# CITY OF ALBUQUERQUE

October 8, 2018

**Re: Orpheum Community Hub**  
**500 2<sup>nd</sup> Street SW**  
**Traffic Circulation Layout**  
Engineer's/Architect's Stamp **10-01-2018** (K14- D114)

C101

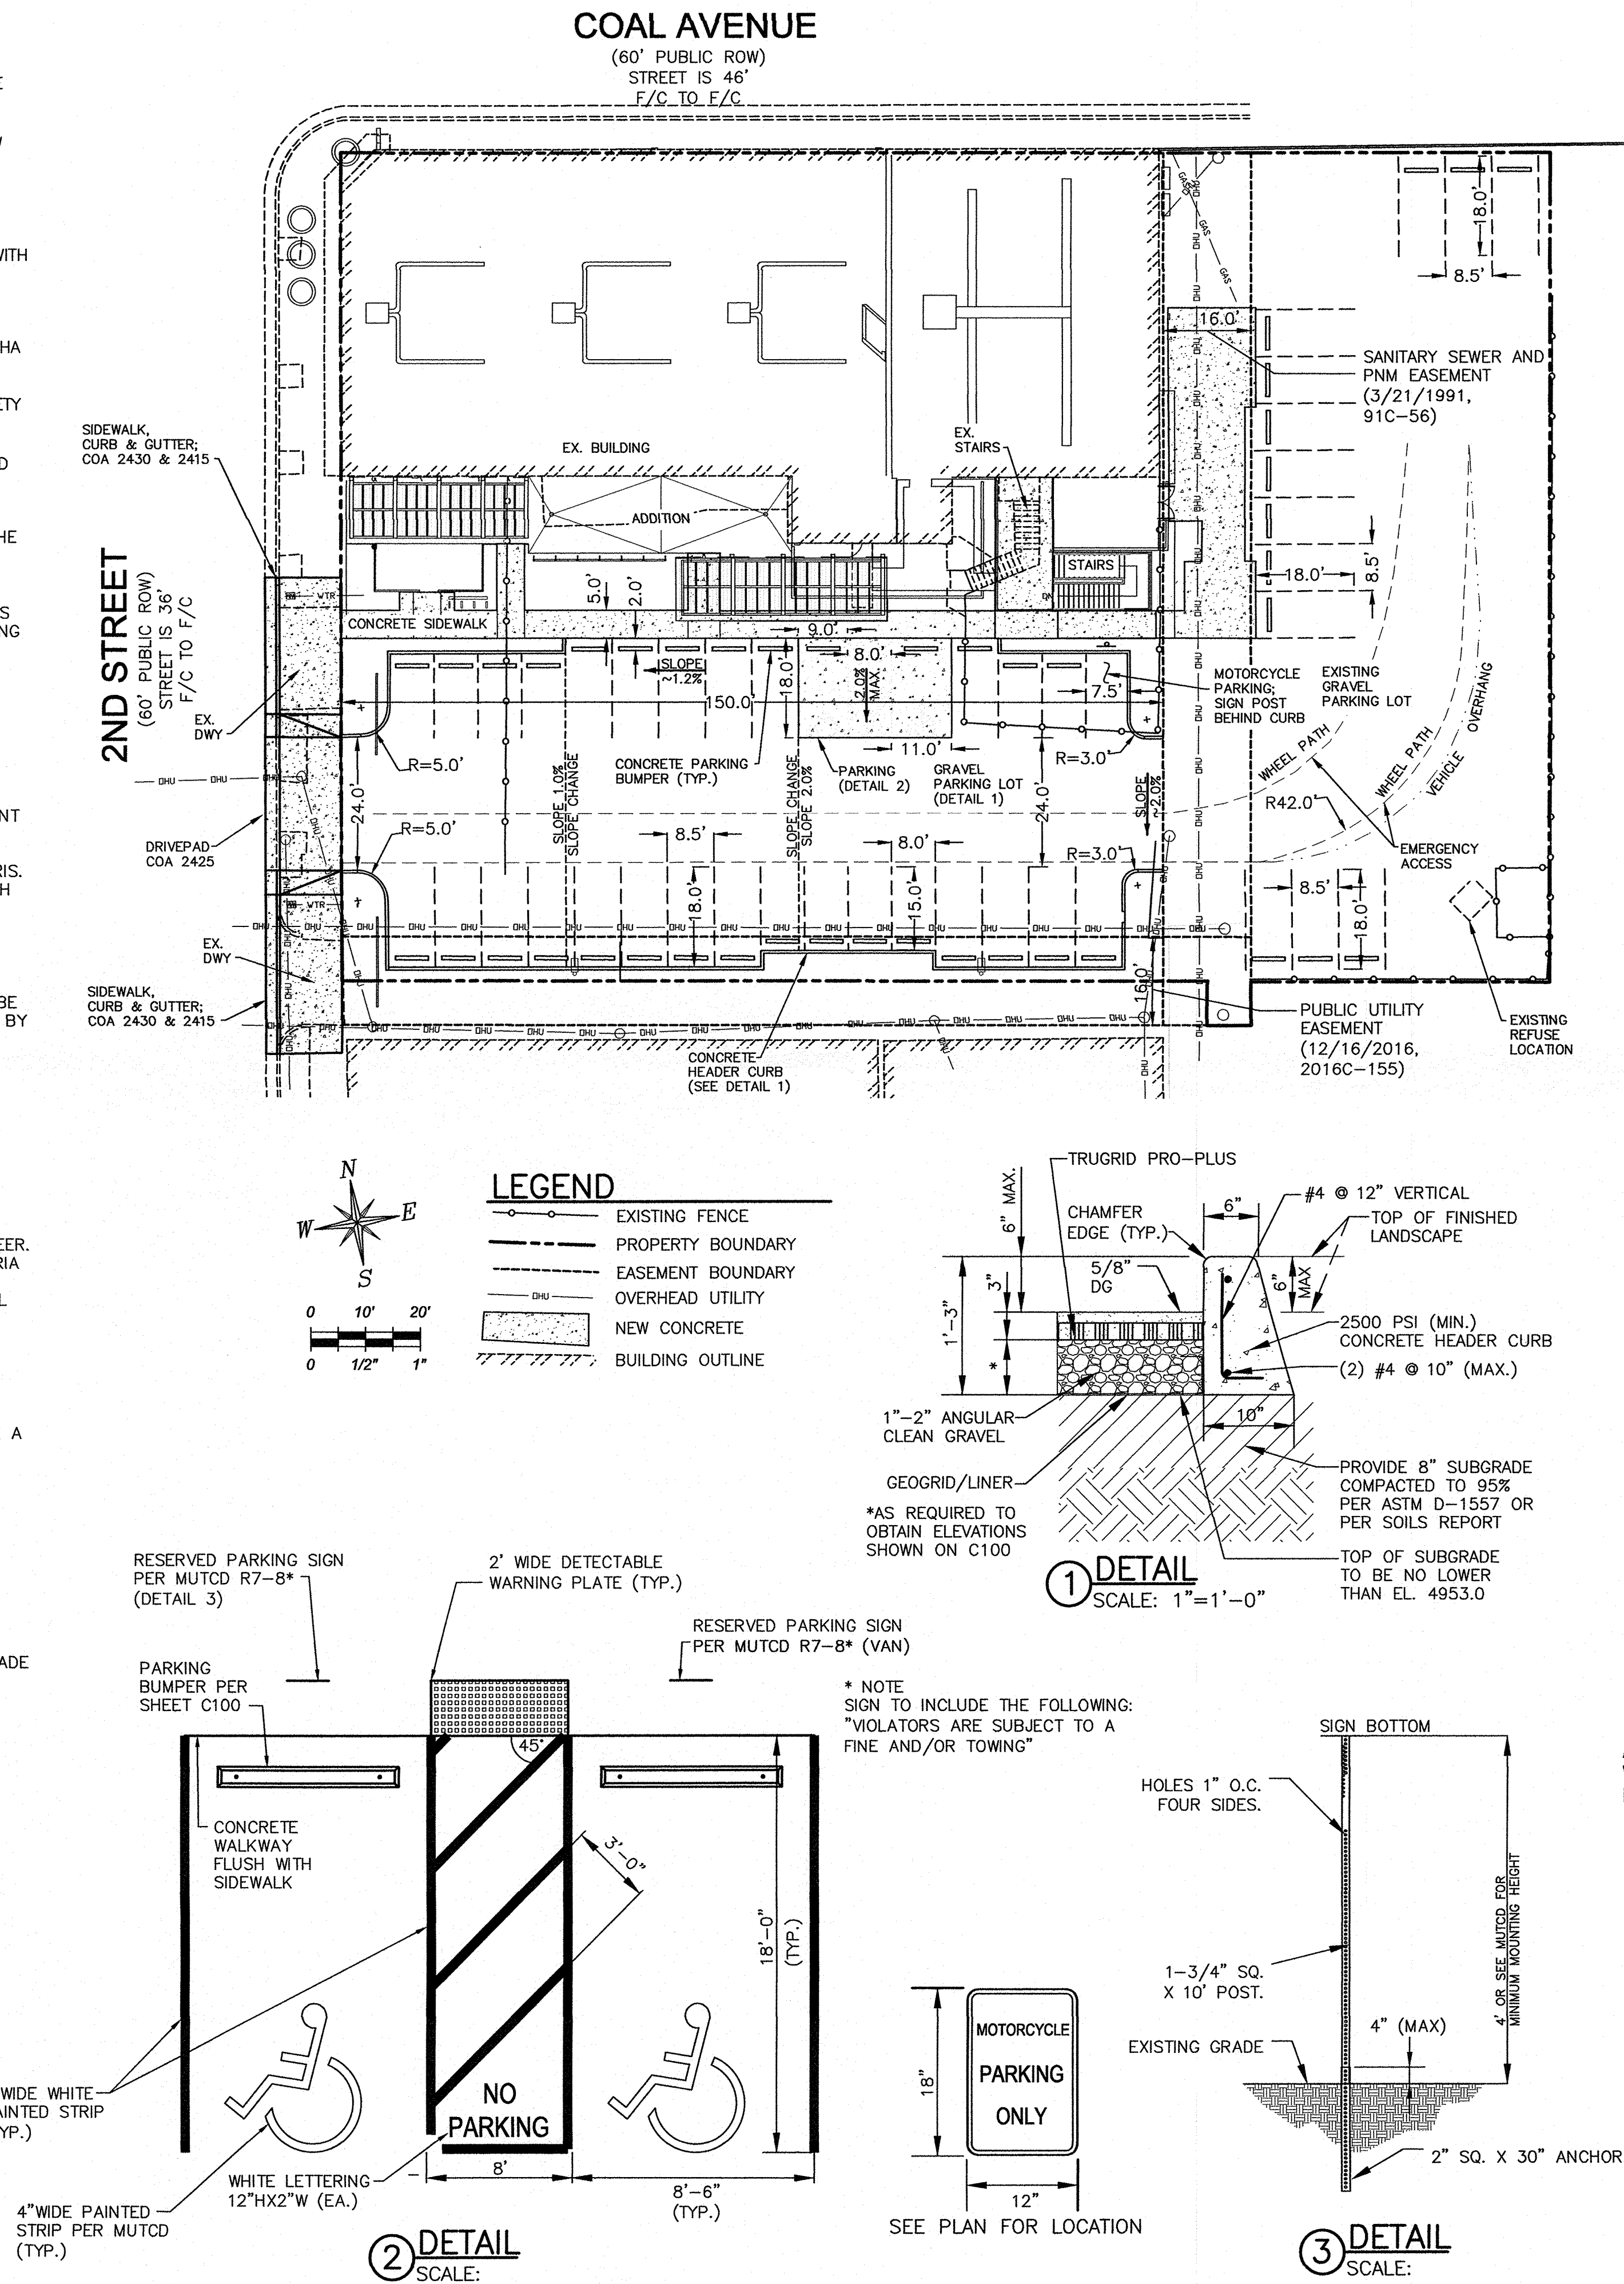
1. The ADA access aisles shall have the words **"NO PARKING"** in capital letters, each of which shall be at least one foot high and at least two inches wide, placed at the rear of the parking space so as to be close to where an adjacent vehicle's rear tire would be placed. (66-1-4.1.B NMSA 1978)
2. Motorcycle parking spaces shall be designated by its own conspicuously **posted upright sign**, either free-standing or wall mounted per the zoning code.
3. Unused curb cuts must be replaced with sidewalk and curb & gutter. A build note must be provided referring to the appropriate City Standard drawing.
4. The 13 spaces on the east portion of the property is not shown. Please Show them on TCL along with their dimensions.
